**KIRKLEES METROPOLITAN COUNCIL
INVESTMENT & REGENERATION SERVICE**

DELEGATED DECISION TO DETERMINE PLANNING APPLICATIONS

Reference No:	2023/62/91626/W
Site Address:	adj, 275, Longwood Road, Longwood, Huddersfield, HD3 4EL
Description:	Demolition of outbuilding and erection of detached dwelling
Recommending Officer:	Katie Chew

DECISION – REFUSED

**Site**  
1 : 100

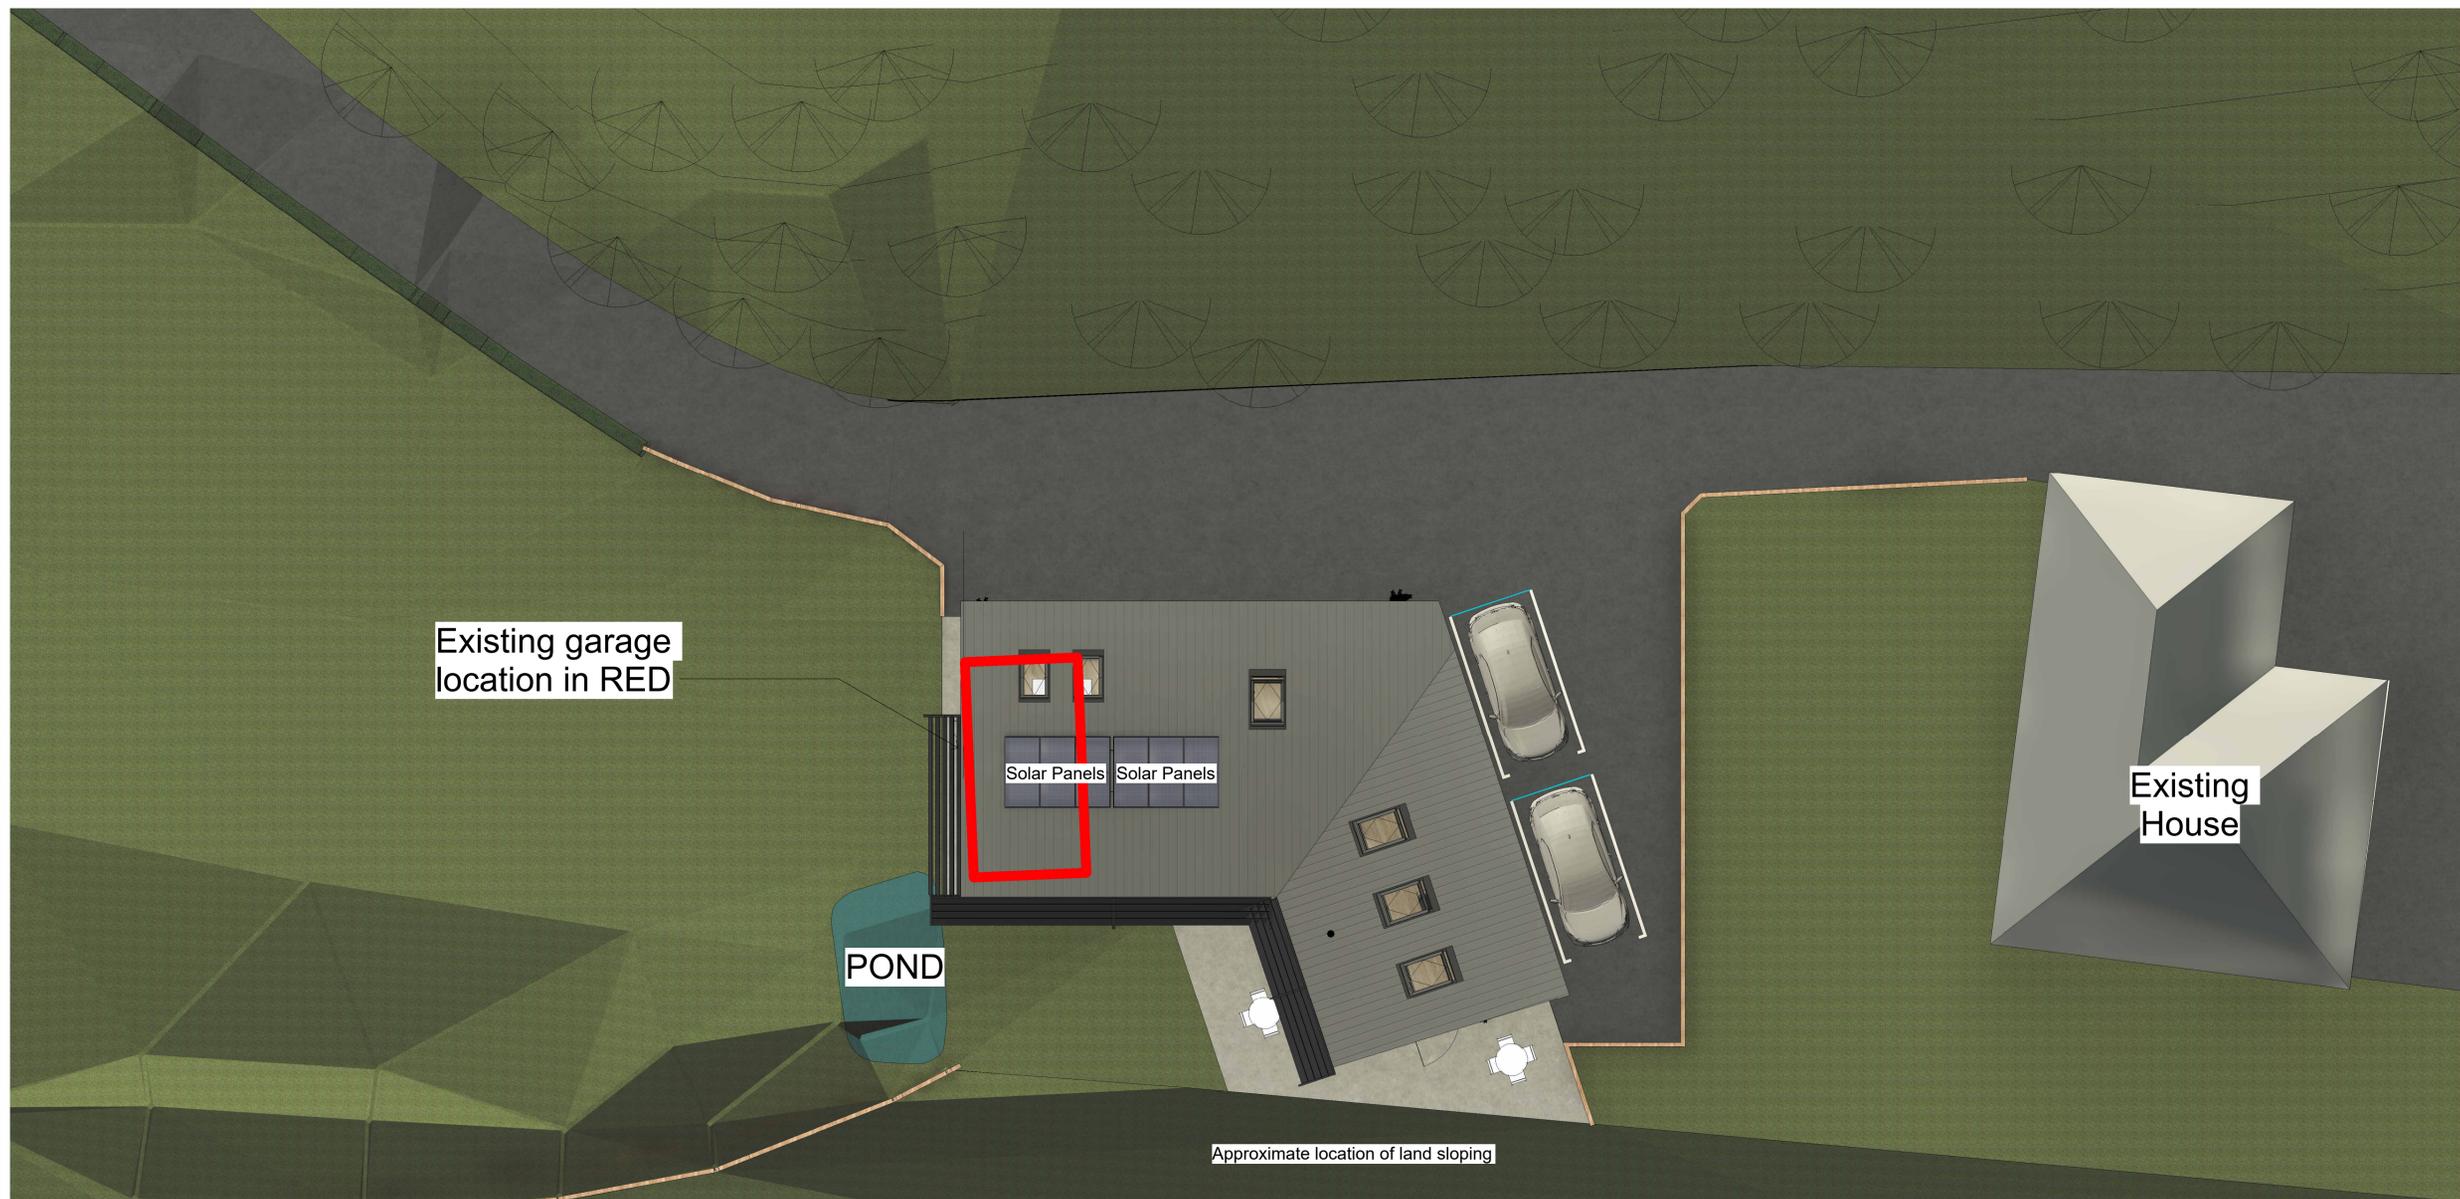
In terms of the layout of the proposed dwelling, the plans submitted indicate the dwelling is to front on to the private driveway and is to be stepped back from the northern elevation (side) of no. 275 Longwood Road. Officers hold the view that the siting and layout of the dwelling is generally acceptable however, it is considered that the dwelling should be reduced in size to the south, to ensure that it does not extend out beyond the rear elevation of adjacent neighbouring property no. 275, this is to retain a coherent building line. Furthermore, it is considered that the design of the dwelling which forms an angled bungalow should be revised to provide a more simple and linear property, which is more reflective of its context and the built-up area surrounding the site.

Moving on to the scale of the proposed dwelling, the plans indicate that the property is to be single storey in height and therefore there are no concerns that the dwelling would appear overbearing in this location. However, Officers do have concerns in respect of the size of the footprint of the dwelling, which given the restricted nature of the site, the dwelling appears visually cramped and is considered to represent overdevelopment of the site. Officers would recommend that the footprint of the dwelling is reduced to provide more space around the dwelling, this would assist with ensuring that the dwelling does not appear overly dominant and is more in keeping with the built form and curtilages provided within the immediate area.

Whilst not overly clear on the submitted plans, it appears that garden/amenity areas are to be provided to the rear with a patio area shown. As outlined above, the dwelling is considered to lead to a development which has a cramped appearance of the site in its current form, therefore, should the dwelling be reduced in size a larger amenity space could be provided for the future occupiers. Whilst it is noted that a significant red line boundary is shown within the plans, this includes a large area to the south which is currently occupied by mature protected trees, a more detailed assessment is provided within the trees section of this report, though removal of these trees as part of the proposals or in the near future would not be considered acceptable and a reduced red line boundary would need to be provided to ensure their retention in the event of any grant of permission.

PROPOSED SOUTH ELEVATION
 1 : 100

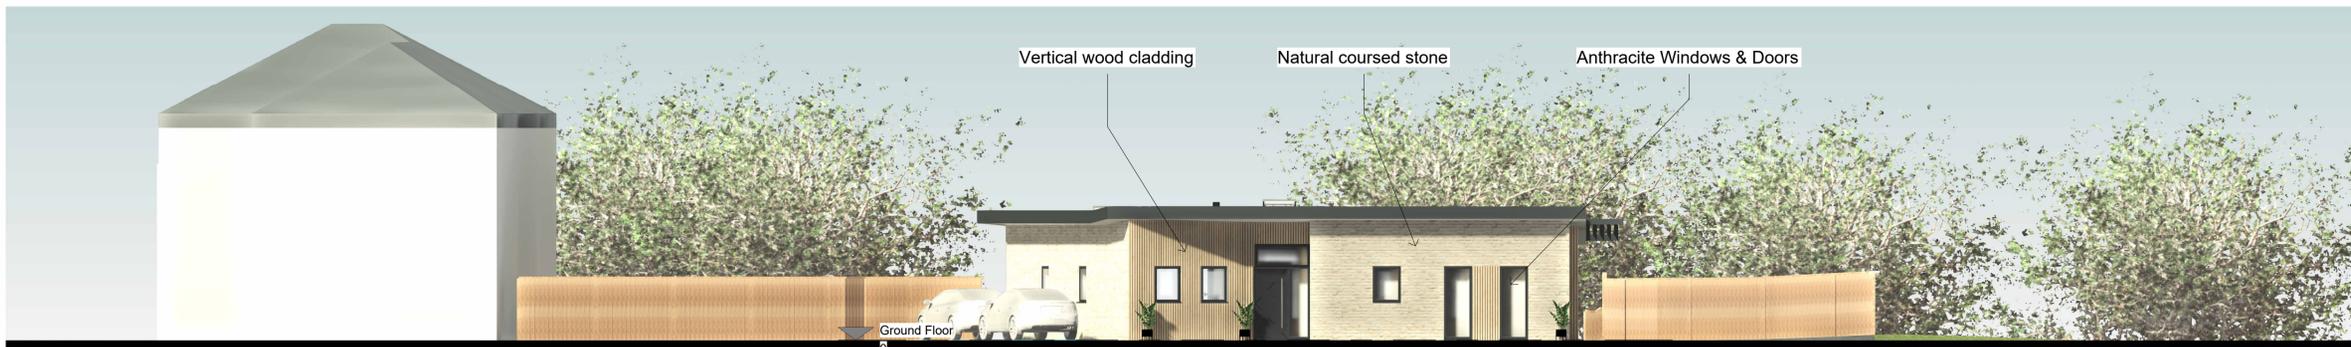
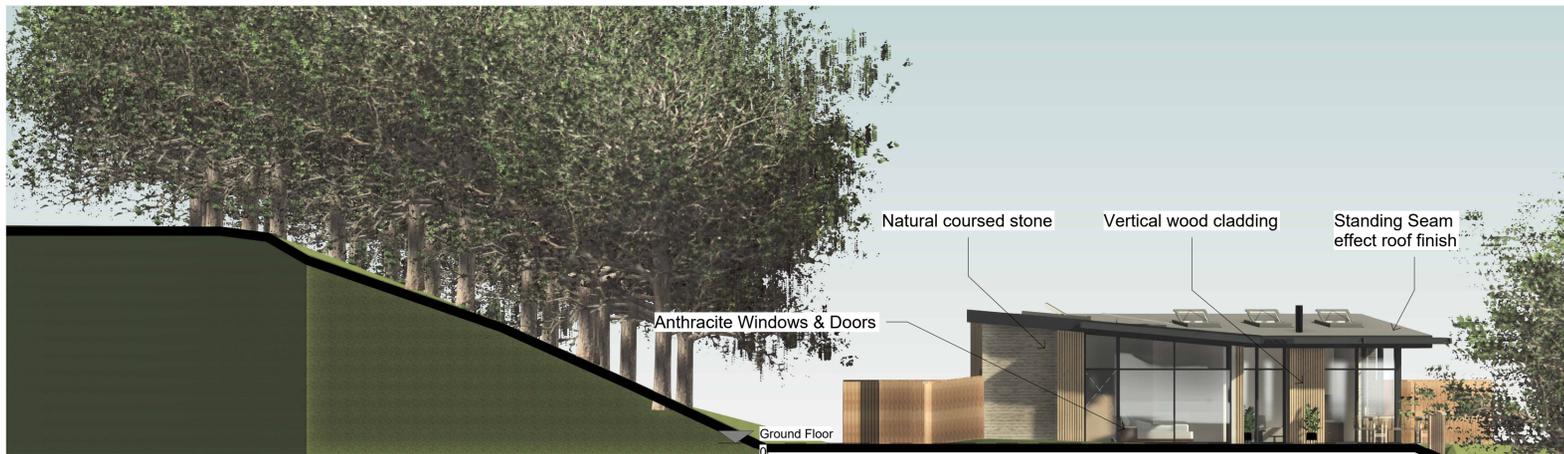
In this instance the proposed dwelling would have a standing seam effect flat roof. This design is not considered to be reflective of the site's context, whereby the proposed dwelling would be viewed against a two-storey traditional dwelling which comprises of a mix of pitched, hipped and flat roof designs. Although Officers acknowledge that there is a small element of a flat roof design at the adjacent property, as this is constructed in traditional materials, this appears to blend in with the surroundings more comfortably. However, when viewing the proposed dwelling the standing seam effect roof and overall design of the building is considered to be overly modern and alien in this location. This is discussed in more detail below.

Looking at the proposed windows and doors within the proposed dwelling, large panels of glazing is proposed on the southern and western elevations. Whilst Officers can acknowledge the benefits to having large panels of glazing on the southern elevation in respect to solar gain, these windows are not considered to be sympathetic and would appear as dominant additions when viewed against the adjacent neighbouring property no. 275. Officers therefore recommend that these be scaled back and be more traditionally placed to

ensure that the new dwelling does not overbear or detract from the traditional setting and appearance of the adjacent neighbouring property.

The proposed dwelling is to be constructed from a mix of natural coursed stone, vertical wood cladding, a standing seam effect roof and anthracite windows and doors. Whilst the use of natural coursed stone is welcomed, should planning permission be granted a condition would be attached requiring samples of the stone to be submitted to the Council for approval to ensure that it is complimentary to the adjacent neighbouring property no. 275 Longwood Road. Officers do however have concerns in regard to the proposed vertical wood cladding and standing seam effect roof which is considered to be incongruous and not reflective of the locality. Officers would recommend that the dwelling is constructed in natural stone with a slate roof.
